A303 Amesbury to Berwick Down

8.6 Statement of Common Ground – Natural England

STATEMENT OF COMMON GROUND – Natural England

Version	Date	Status of Version
Rev 0	03.05.2019	Deadline 2 Issue

Drawing Number HE551506 -AMW	1 Originator	1 Volume	Rev 02
SW_GN_000_Z	-EL5	-DR-LE -1001	
Location	I Type	I Role	I Number

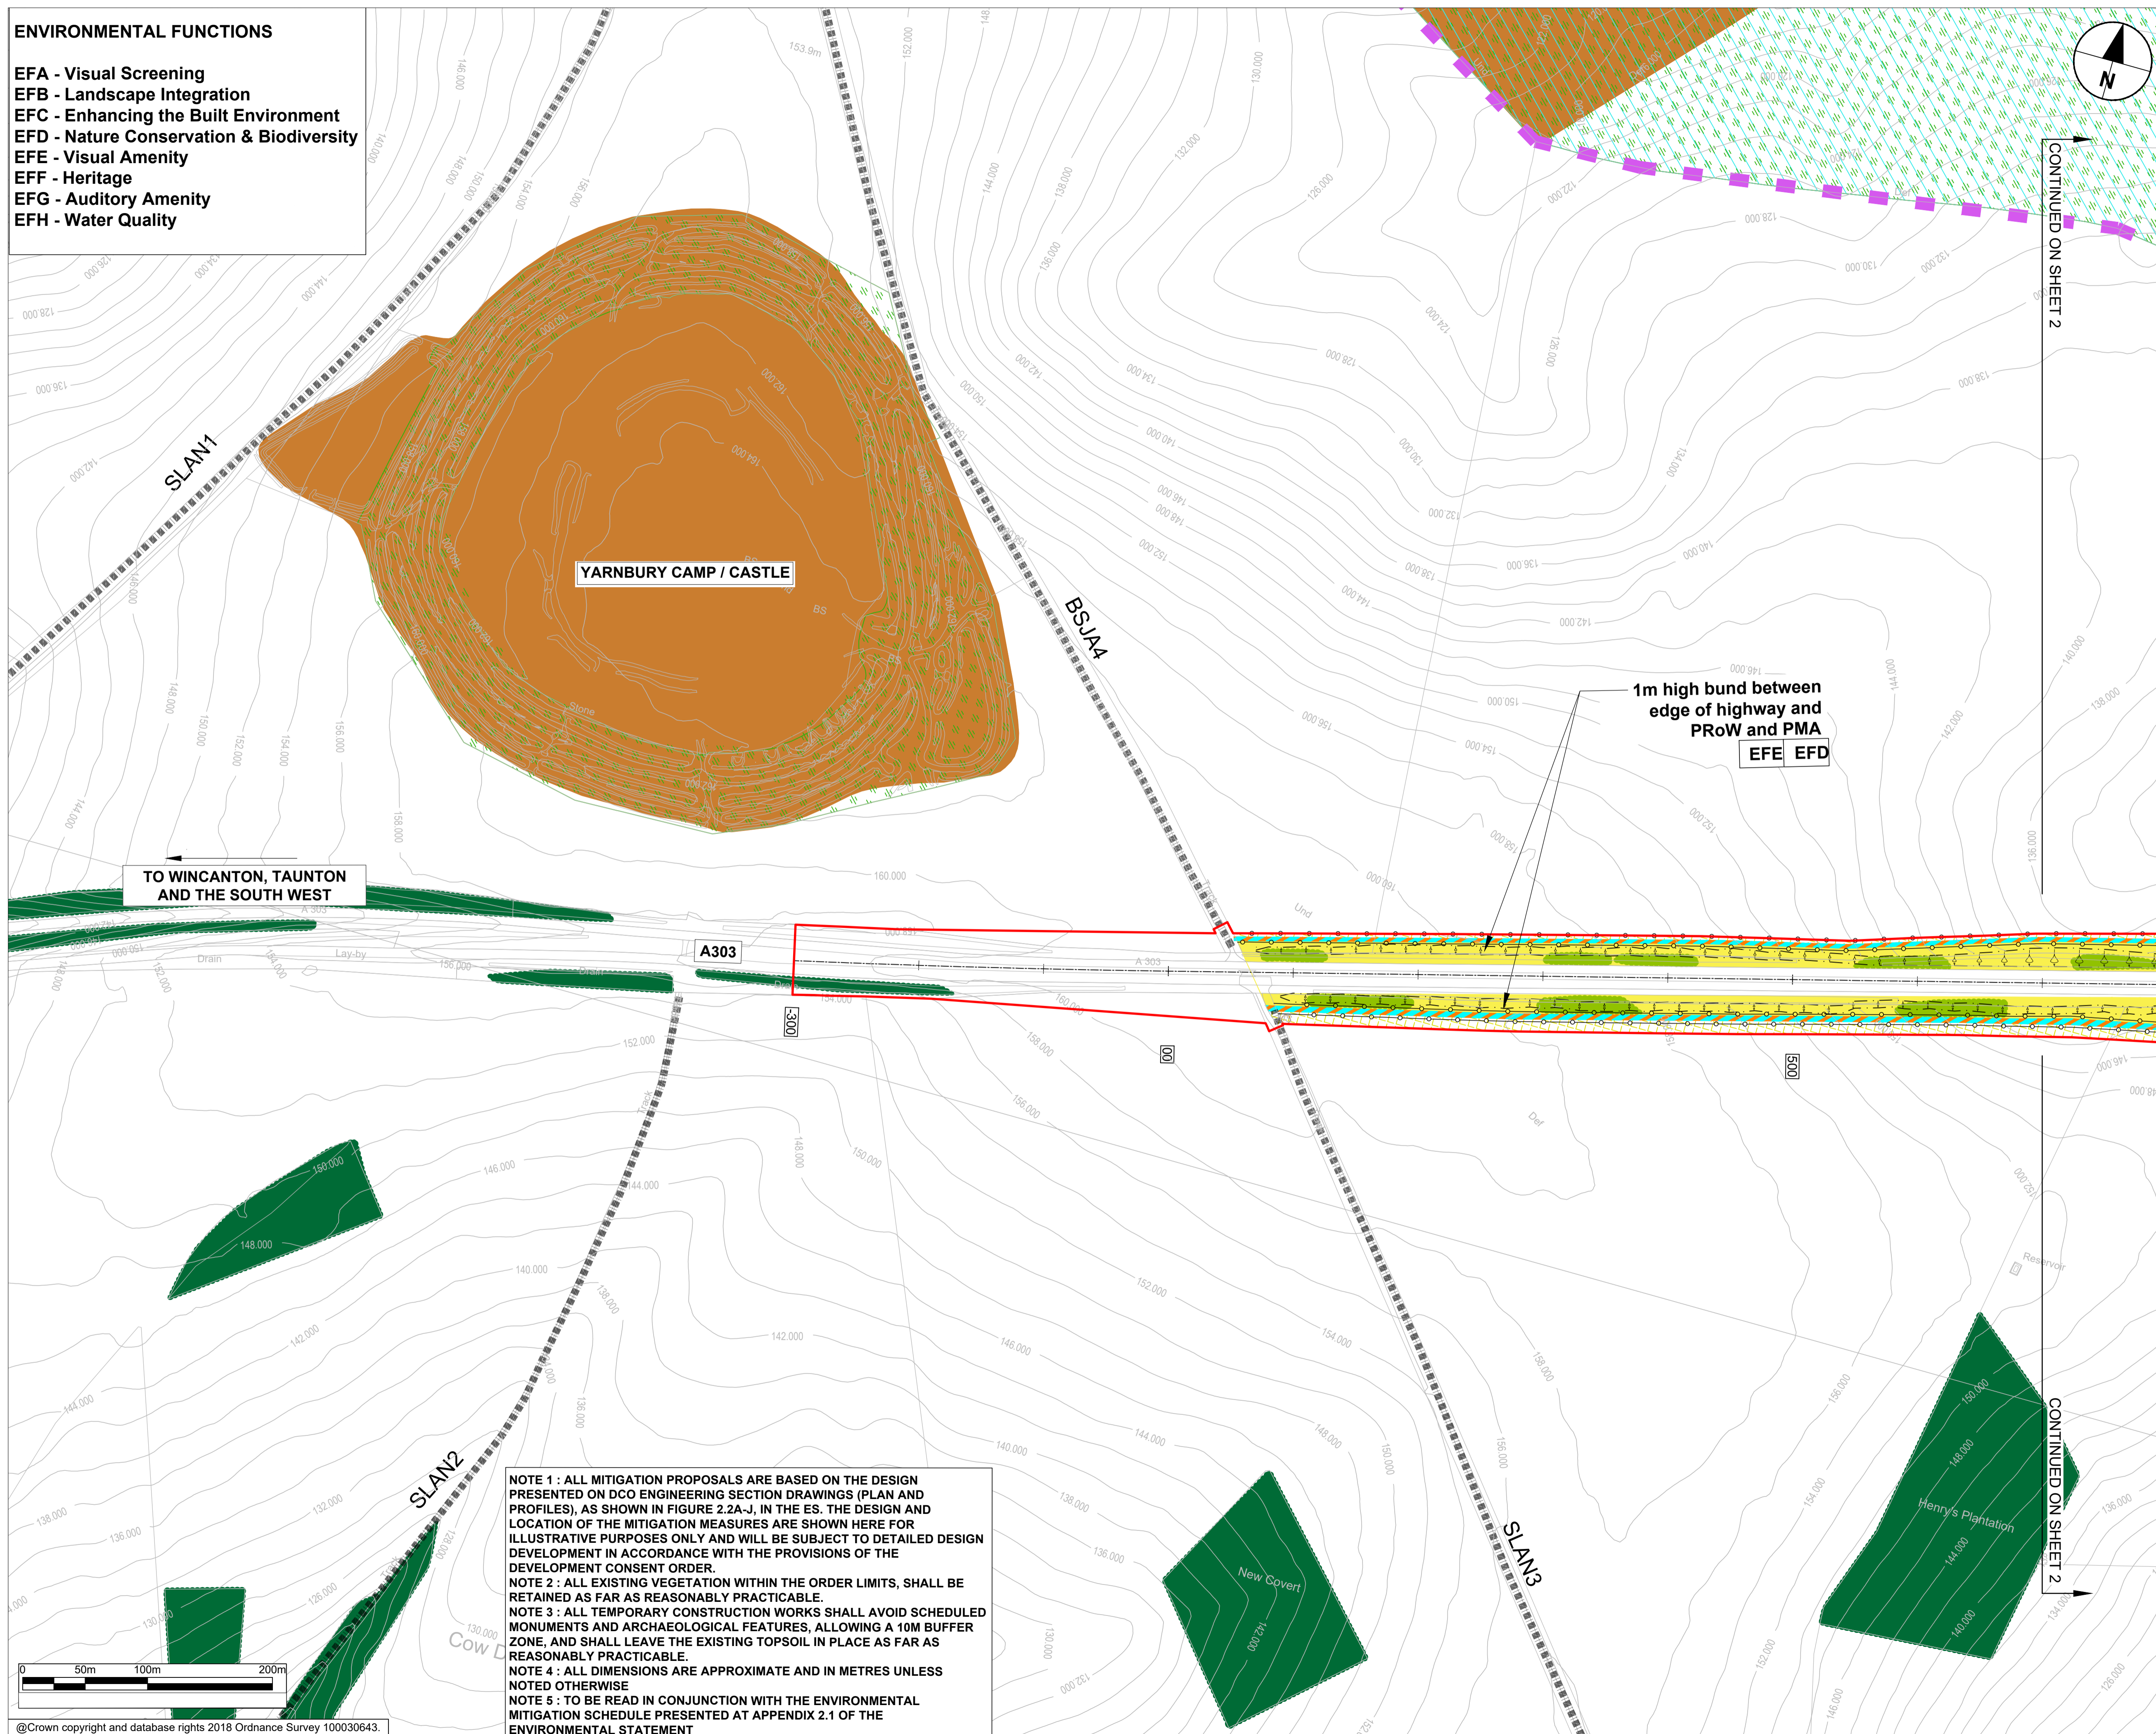
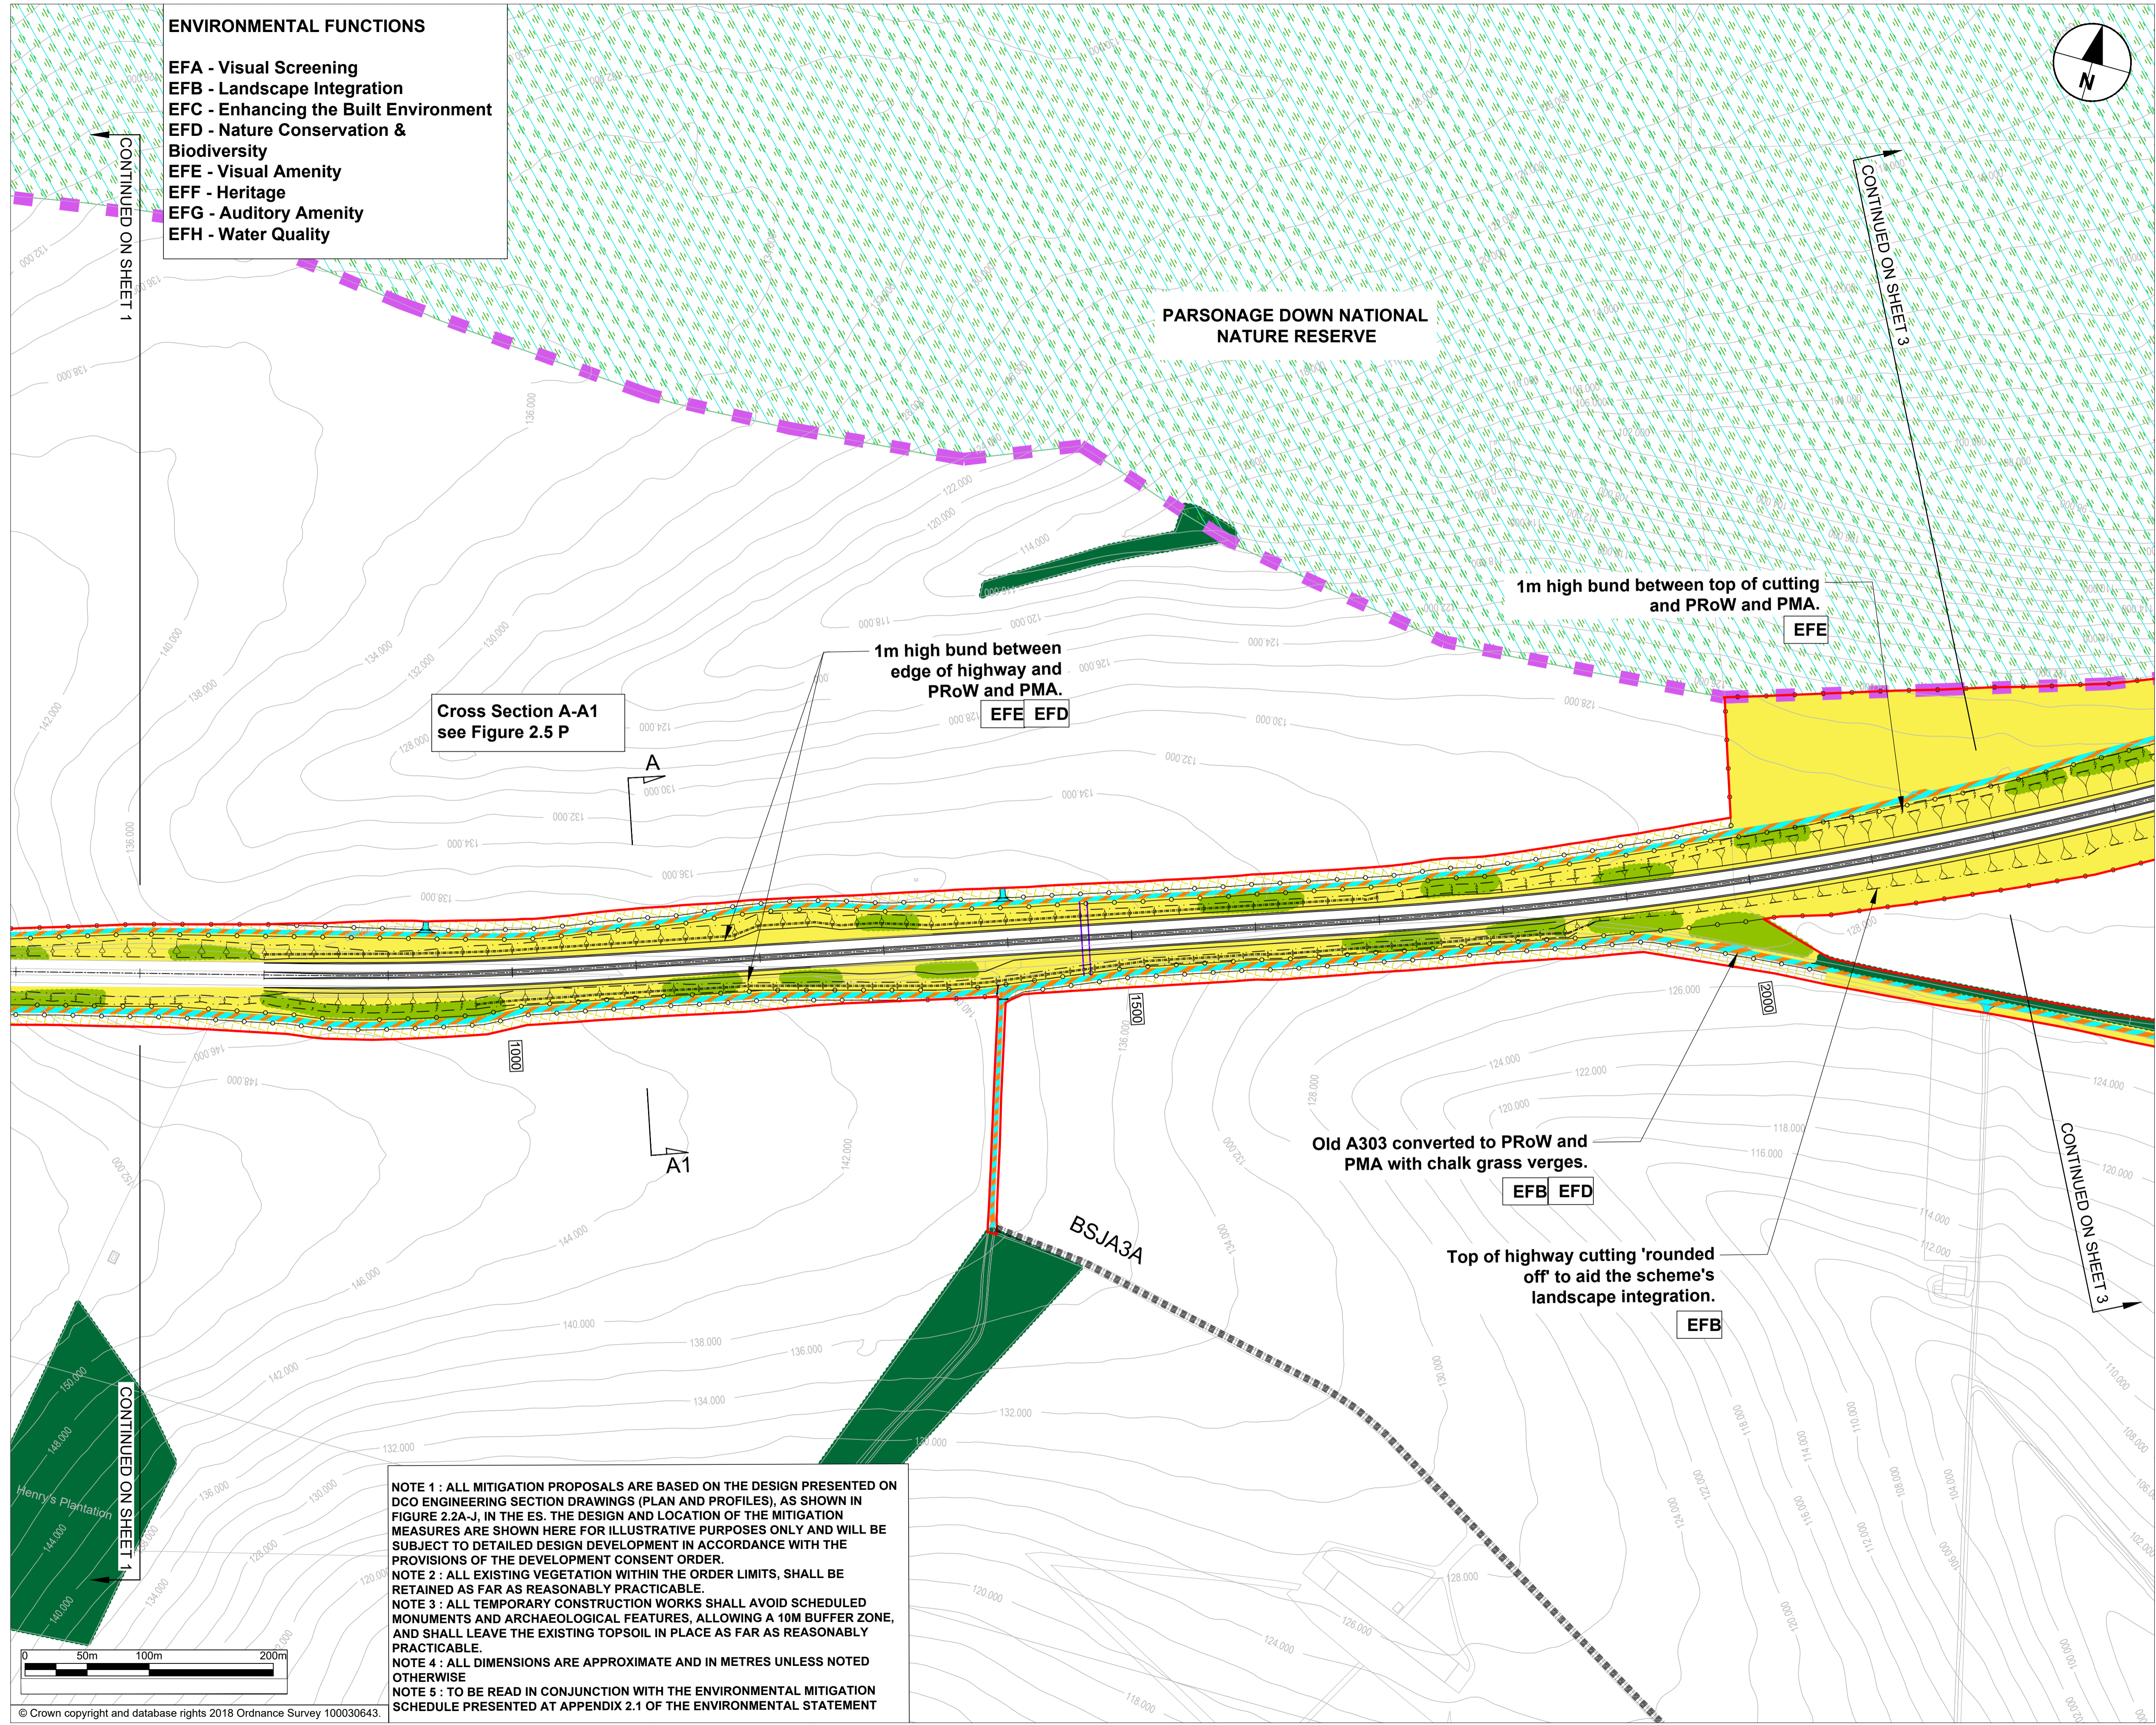
3.7	Environmental Statement Chapter 8 Biodiversity [APP-046] and Figure 2.5 Environmental Masterplan [APP-059]	Table 8.14	Embedded mitigation Shrub planting	<p>The Environmental Masterplan includes numerous areas of shrub planting. These are liable to become management liabilities requiring expenditure on scrub control much greater than if left unplanted and likely to be detrimental in the long term to biodiversity. We are not clear what the purpose of planting these areas and advise each is only retained if there is a good reason to do so.</p>	<p>Discrete areas of shrubs have been included in the scheme as shown indicatively in the Environmental Masterplan [APP-059] to provide a landscape link, for screening purposes and to provide a mosaic of habitats.</p> <p>The shrubbed areas will be designed taking into account the need to avoid future management issues associated with rapidly expanding scrub. The principles of creation and management of these shrubbed areas are set out in the</p>	Agreed

3.8	Environmental Statement Chapter 8 Biodiversity [APP-046] and Figure 2.5 Environmental Masterplan [APP-059]	Table 8.14	Embedded mitigation - Woodland creation	Whilst early successional chalk habitats are the primary ecological aspiration for the scheme, the modest levels of woodland creation provide useful landscaping and are not without their ecological benefits in terms of habitat diversity in general and key bat species.	Agreed between Natural England and Highways England 11 January 2019	Agreed

from Winterbourne Stoke via Green Bridge 1 is especially welcome in this context.		
3.10	Environmental Statement Chapter 8 Biodiversity [APP-046] and Figure 2.5 Environmental Masterplan [APP-059]	Table 8.14	Embedded mitigation Hedgerow creation	Hedges should be used to separate arable land from species rich chalk grassland, as this will help reduce spray drift onto the grassland and provide a valuable habitat in its own right. These benefits will outweigh the negative effect of encouraging the spread of scrub onto the species rich chalk grassland, provided the species mix for the hedge does not include rapidly spreading species such as dogwood or blackthorn. These should be excluded from the planting mix. On this basis, it would appear that there are additional locations where hedgerow planting may be beneficial.	All hedgerows within the DCO boundary to be retained will be managed during the construction phase. This is secured by the OEMP (MW-G28) [APP-187], which is required to be implemented pursuant to paragraph 4 of schedule 2 to the draft DCO. Hedgerows have been included in the scheme as shown indicatively in the Environmental Masterplan [APP-059] to provide a landscape link, for screening purposes and as suitable boundaries.	Agreed

Outline Landscape and Ecology Management Plan ('OLEMP') [APP-267], details of which, are secured as part of the landscaping scheme pursuant to Requirement 8 (Implementation and maintenance of landscaping) under Schedule 2 of the DCO [APP-020].
